From: Simon Davis
Sent: 05 February 2019 13:01
To: Planning.Responses
Subject: FW: Y/102/18/DOC (Condition 13 Construction Management Plan)

I am writing about the CMP that was submitted to WSCC for the Bovis site at Burndell Road in Yapton.

SITE COMPOUND

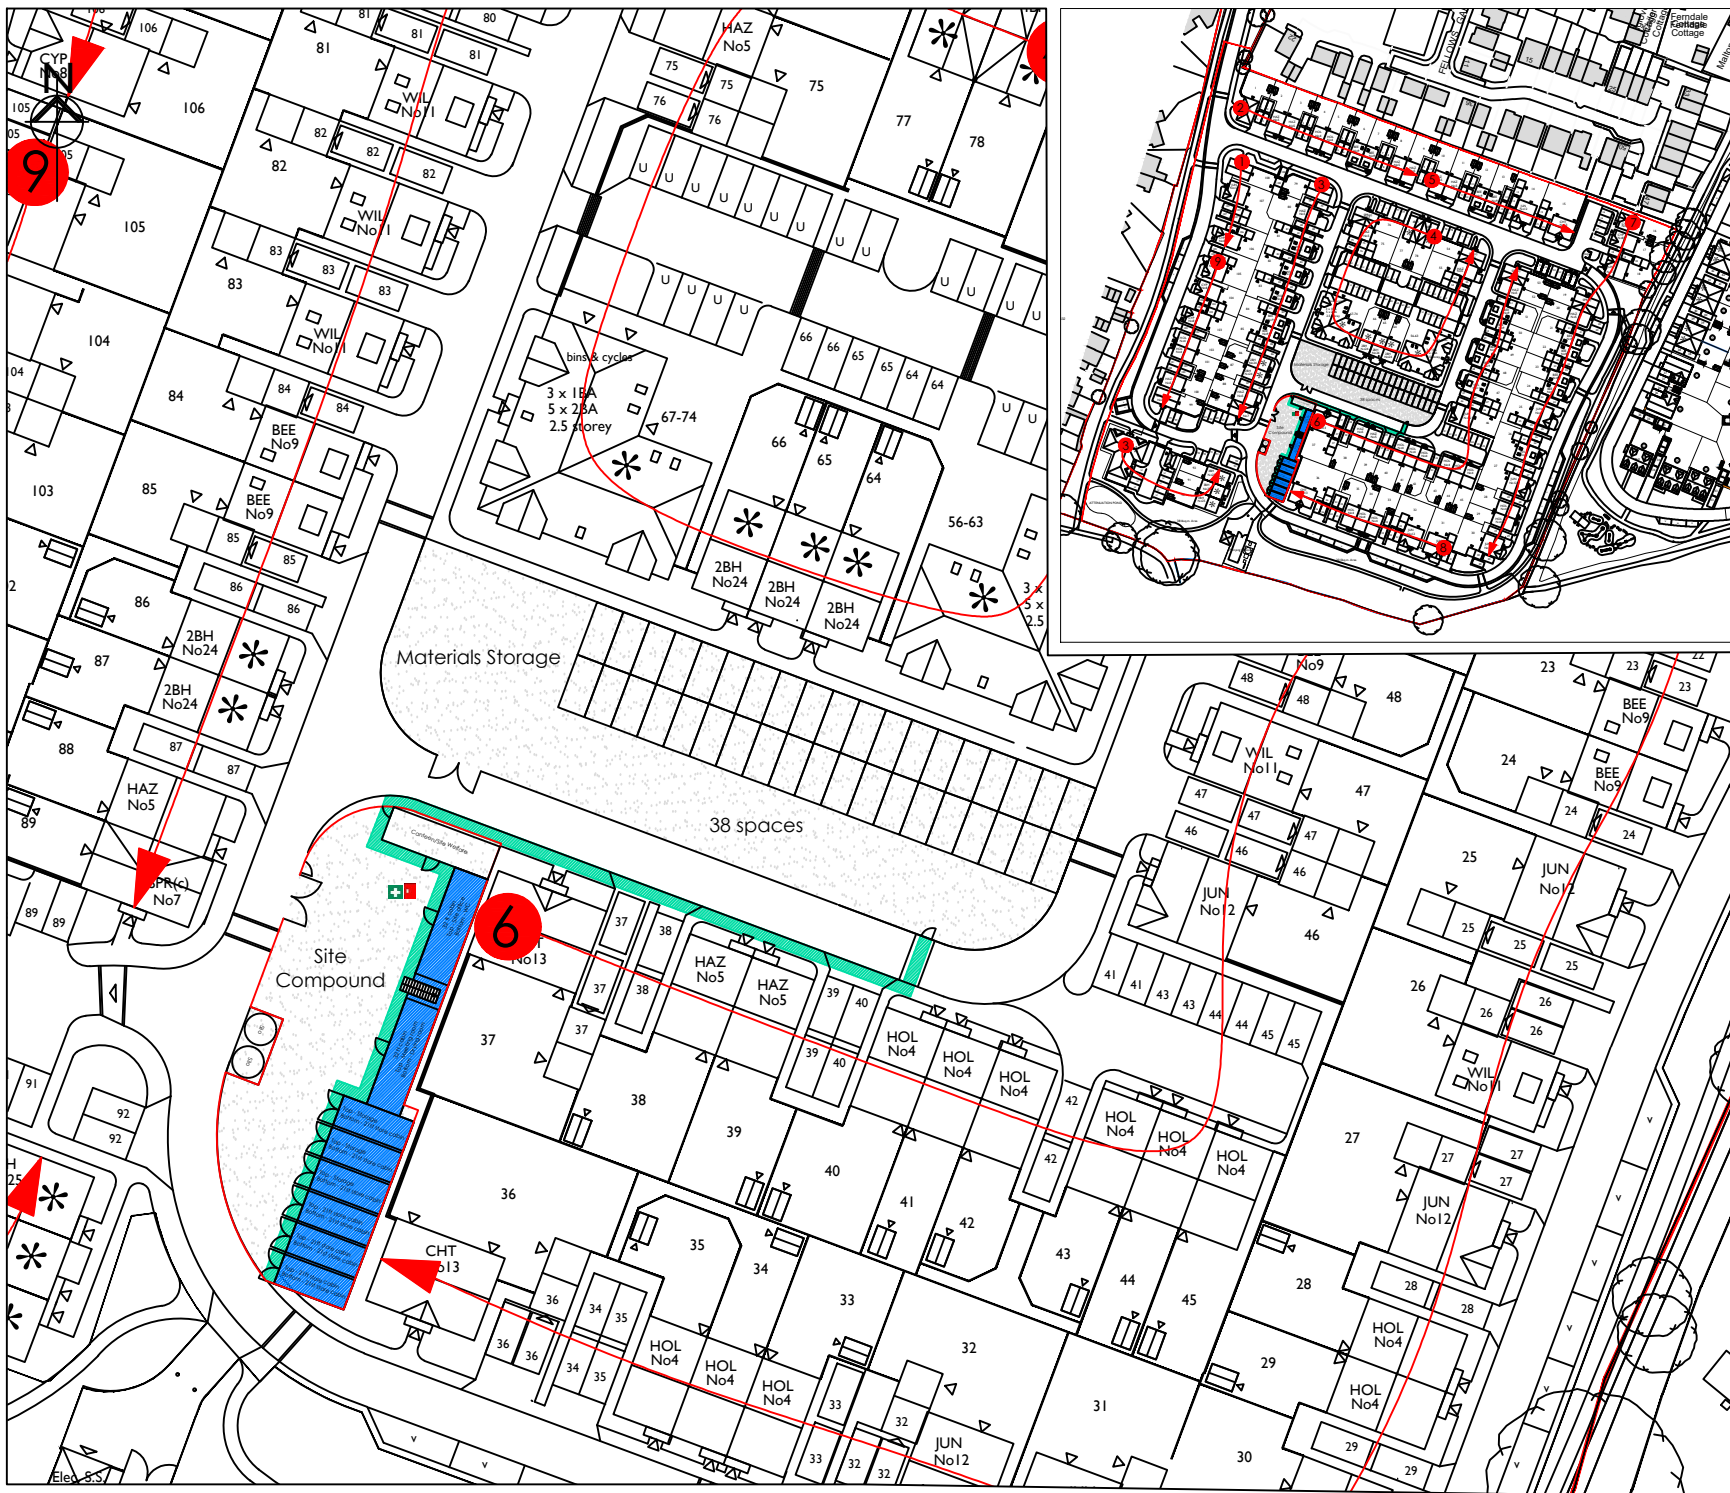
Yes, I am happy with this. However, I'd still like to see the gates set-back from the highway to at least allow a car or light van clear access off the highway – so say 5-6 metres, please.

'Hoarding needs to be set-back 20m from kerb-line on Burndell Road to accommodate large vehicles and to ensure that they don't overhang the highway. Please confirm and show that this will be the case.'

Would we be able to leave the gates open during the hours of construction, with a banksman and signage at the entrance, bringing in vehicles up to a 'checkpoint' at least 20m in the site, to ensure they do not overhang the highway. That way, the site can still remain secure at night.
